Online Comment

Application H16-0208-26
Location 28 Westlode Street Spalding Lincolnshire PE11 2AF
Proposal Change of use from cafe/restaurant (Use Class E) to ground floor flat (Use Class C3)

Name Imogen Colenutt, Assistant Conservation Officer
Address Council Offices The Hub Mareham Rd LN9 6PH

PROPOSED FRONT ELEVATION. 1:50.

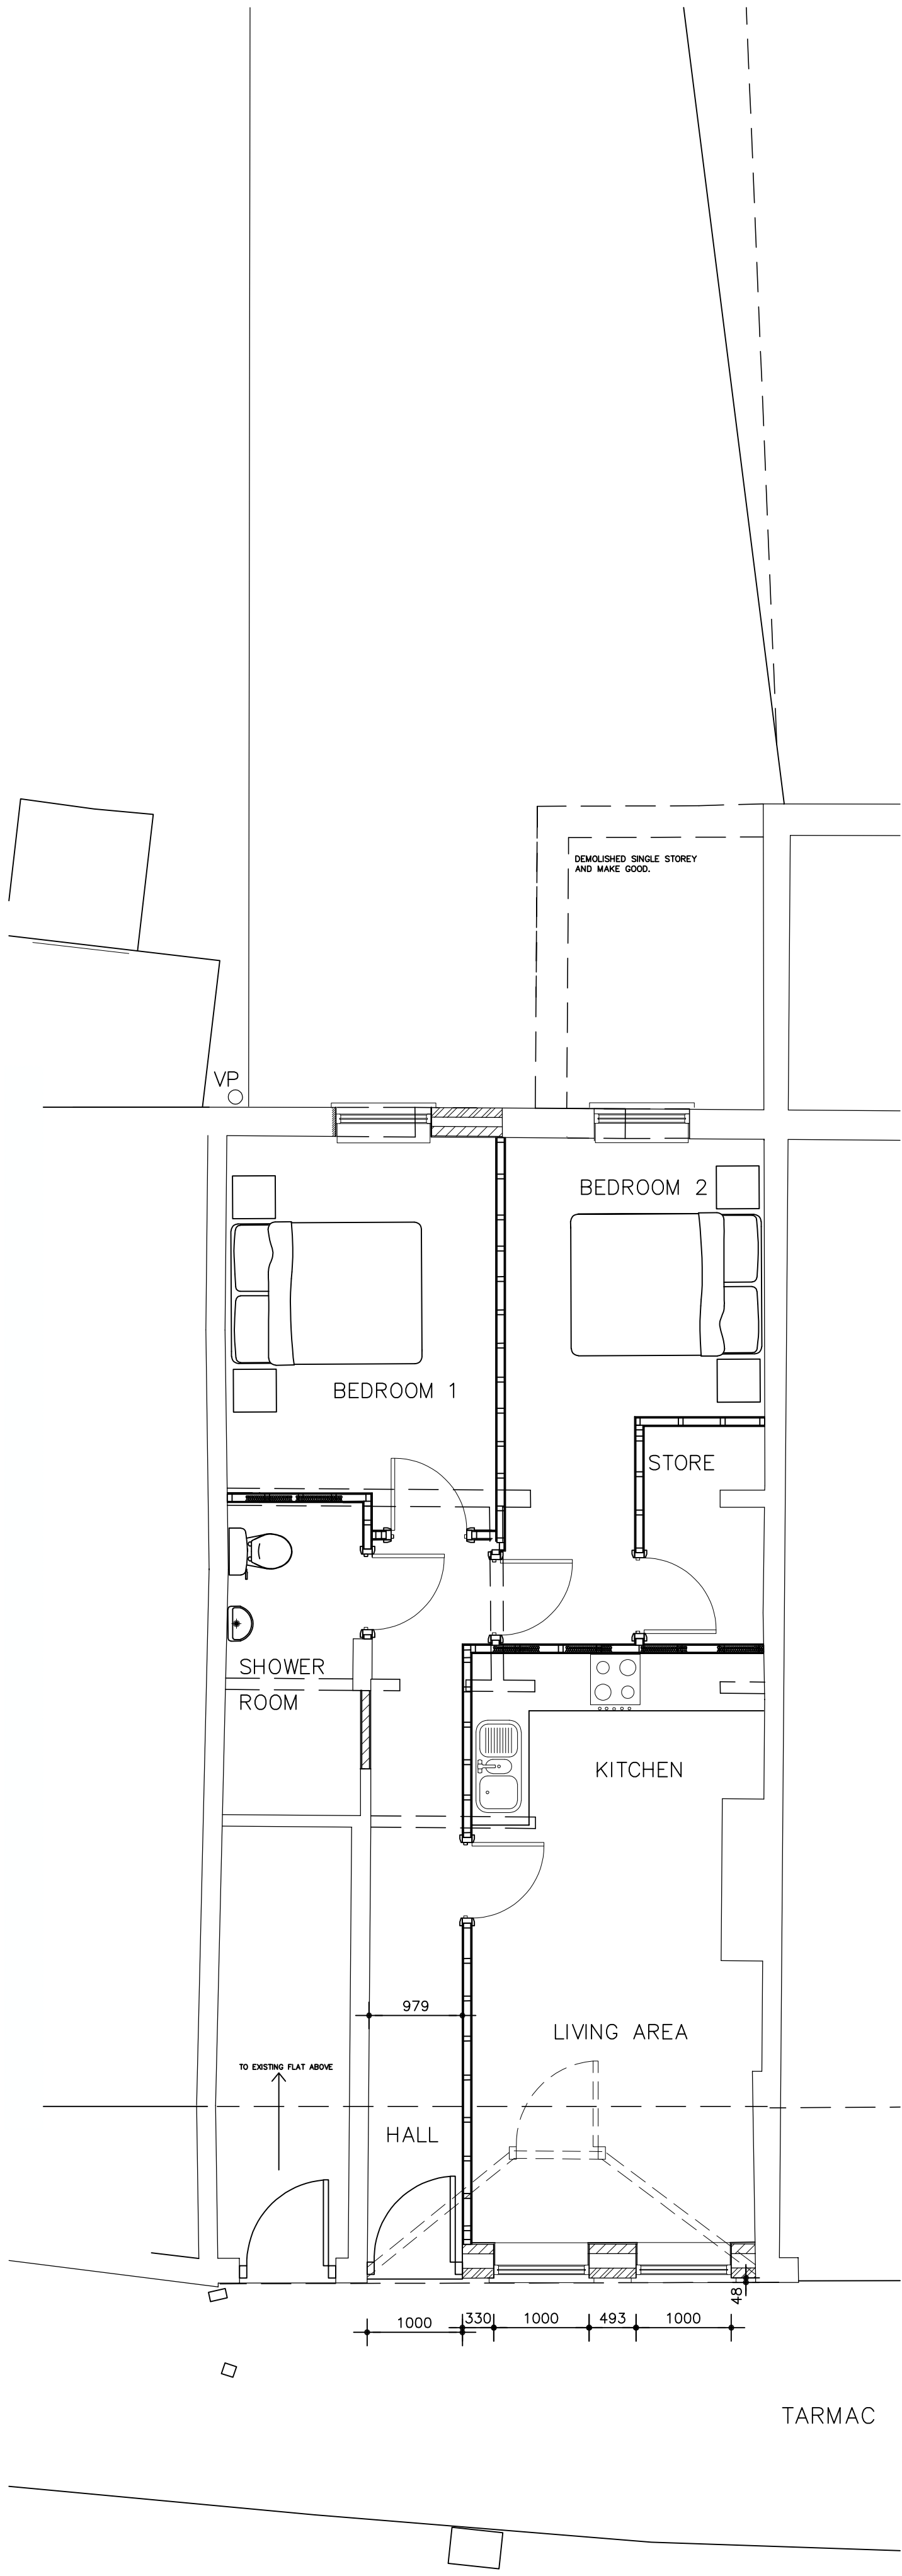
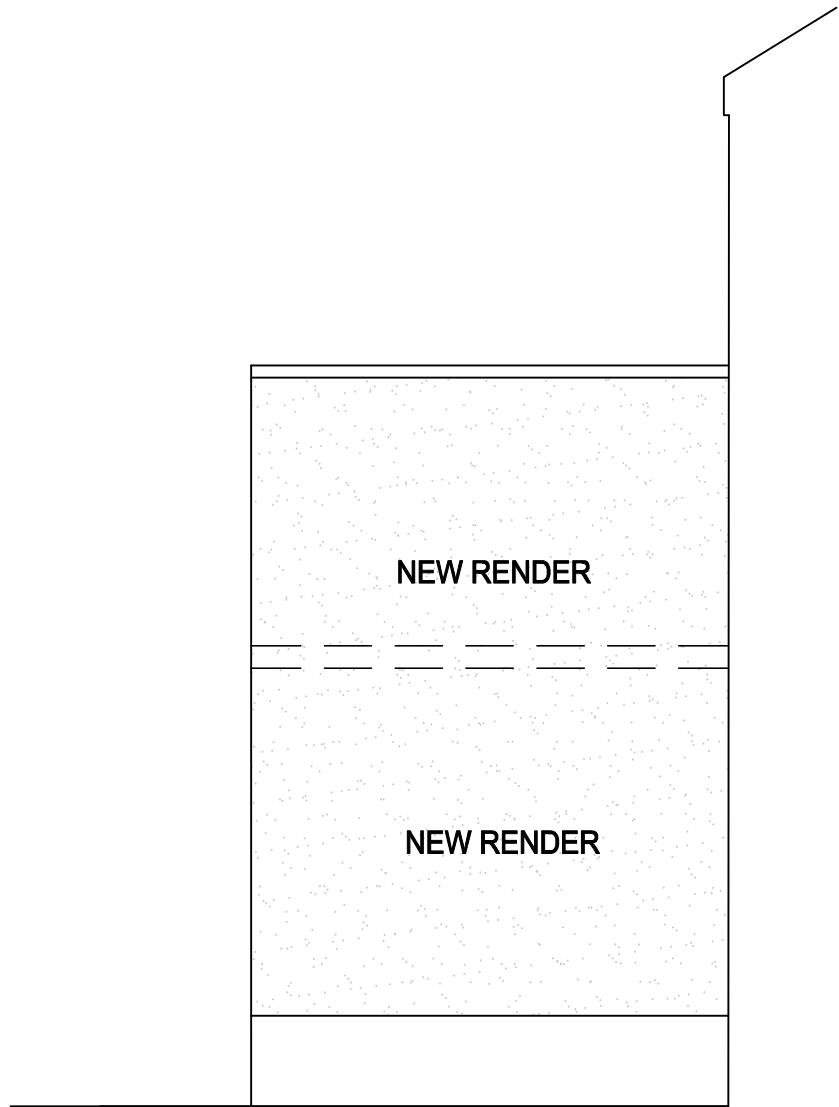
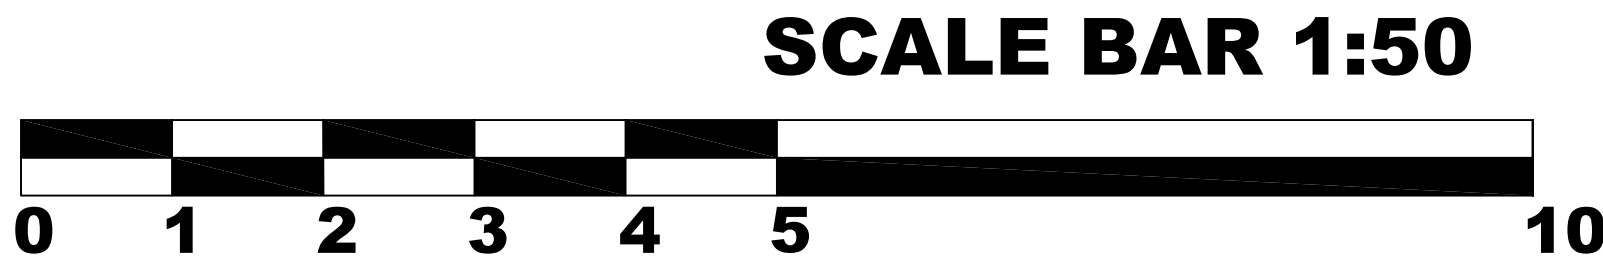
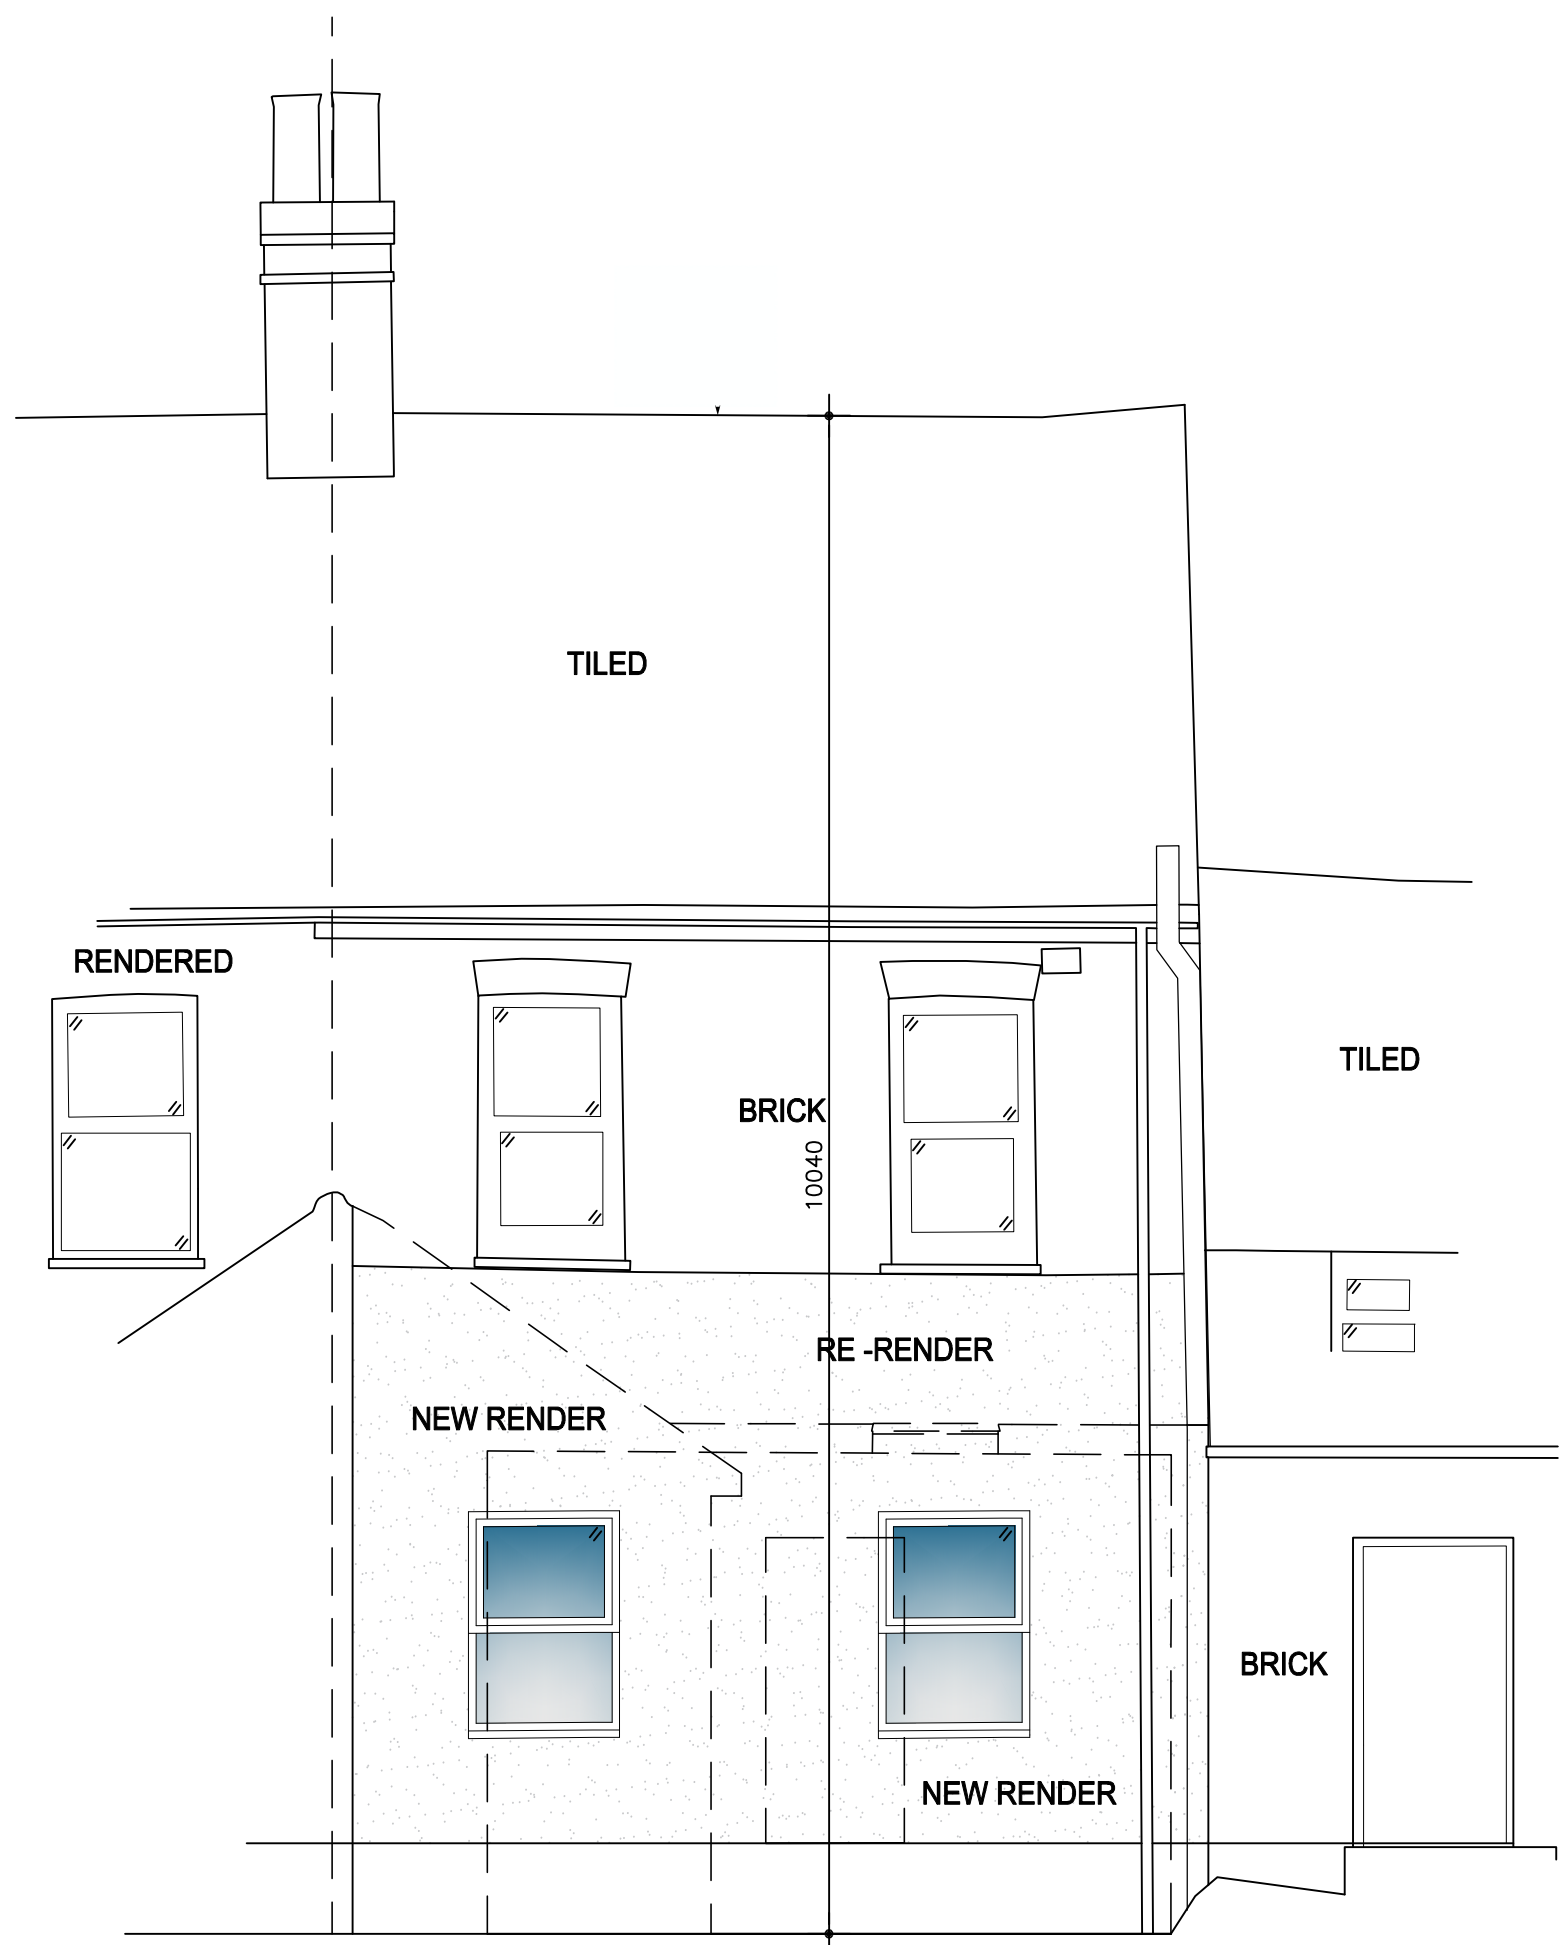
The frontage should continue to read as a shopfront, acknowledging the building's previous use. Additionally, there is concern regarding the extent of new brickwork proposed, particularly in relation to achieving an accurate and appropriate brick match that would not be harmful to the appearance of the Conservation Area.

Reinstating shopfront elements, such as a stall riser and a single large display window, would help preserve the established shopfront character of the building. This approach would also significantly reduce the amount of new brickwork required, thereby minimising visual harm and better aligning the proposal with the character and appearance of the Conservation Area.

If possible, access should be provided via the existing door to the flat above. However, this door should be replaced with one that is more in keeping with the character and appearance of the Conservation Area.
